Submission link http://majorprojects.planning.nsw.gov.au/index.pl?action=view_job&job_id=9579

Concept State Significant Development Application – SSD 18_9579 Crows Nest Overstation Development - Submission

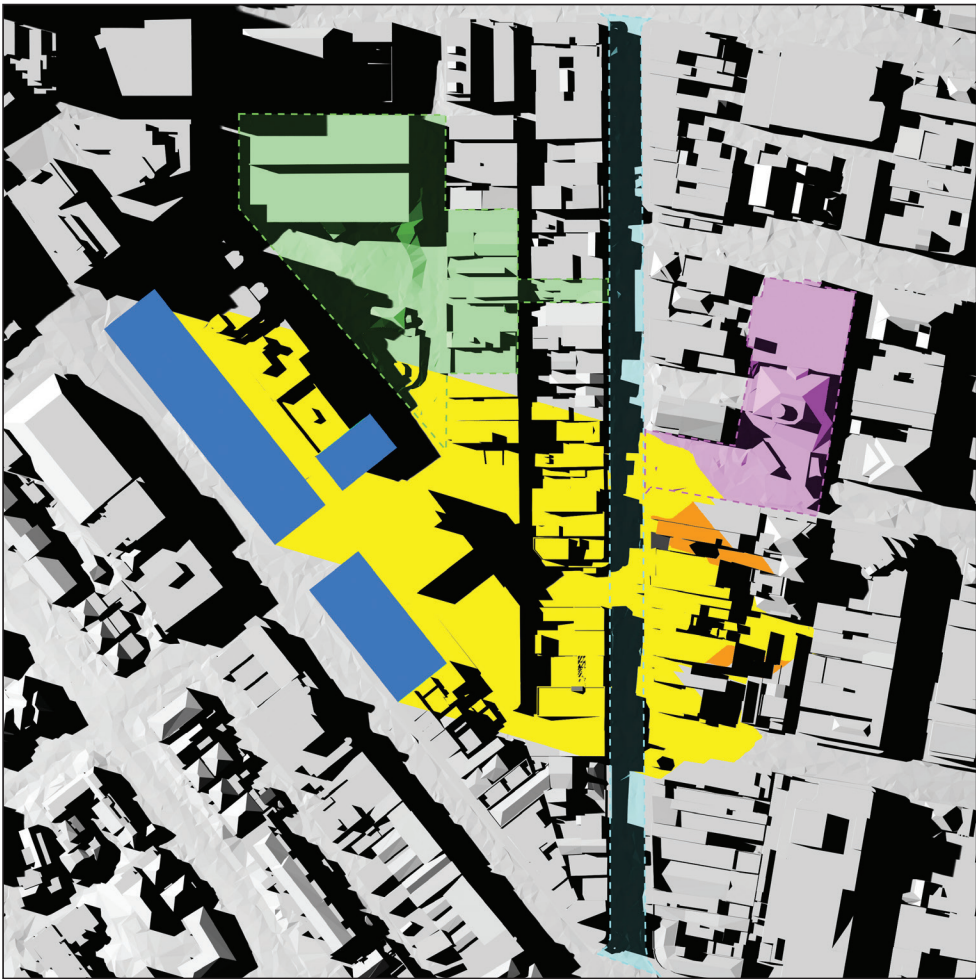
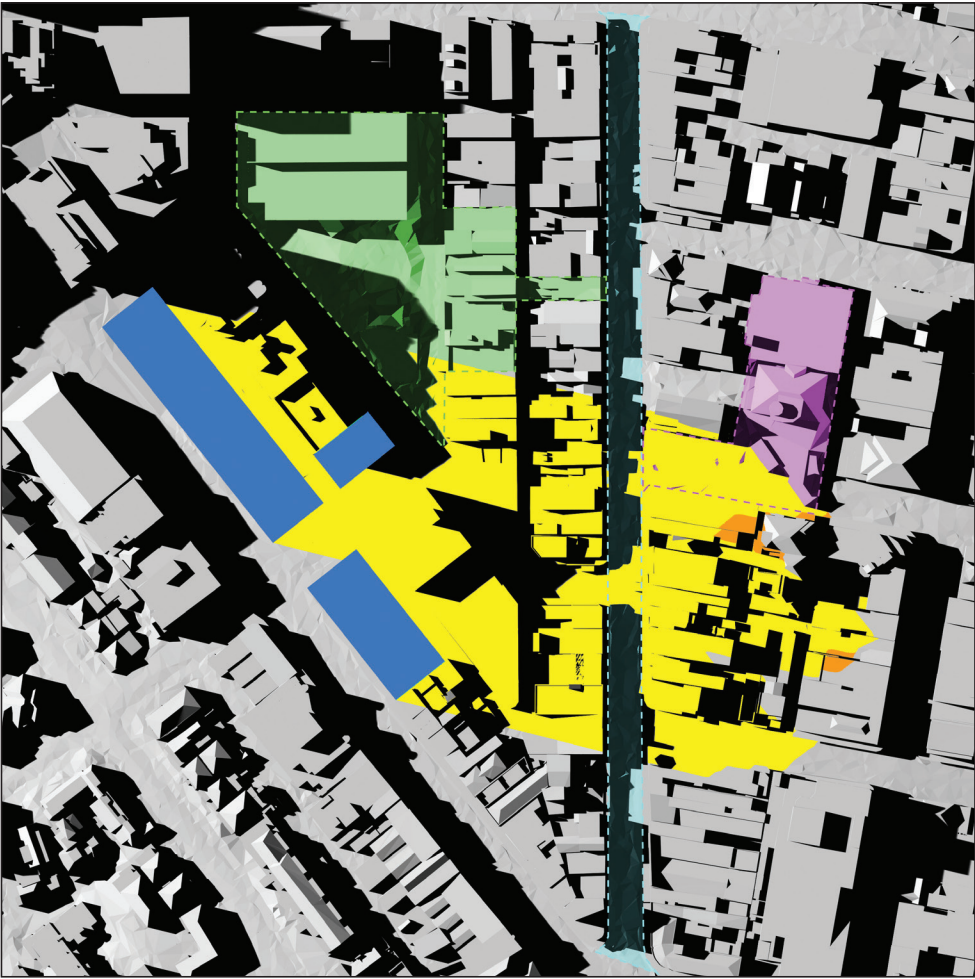
- I object to the overshadowing of Nicholson Street, Hume Street Park, Willoughby Road and Ernest Place in particular year-round, not just between 9.00 am and 3.00 pm.
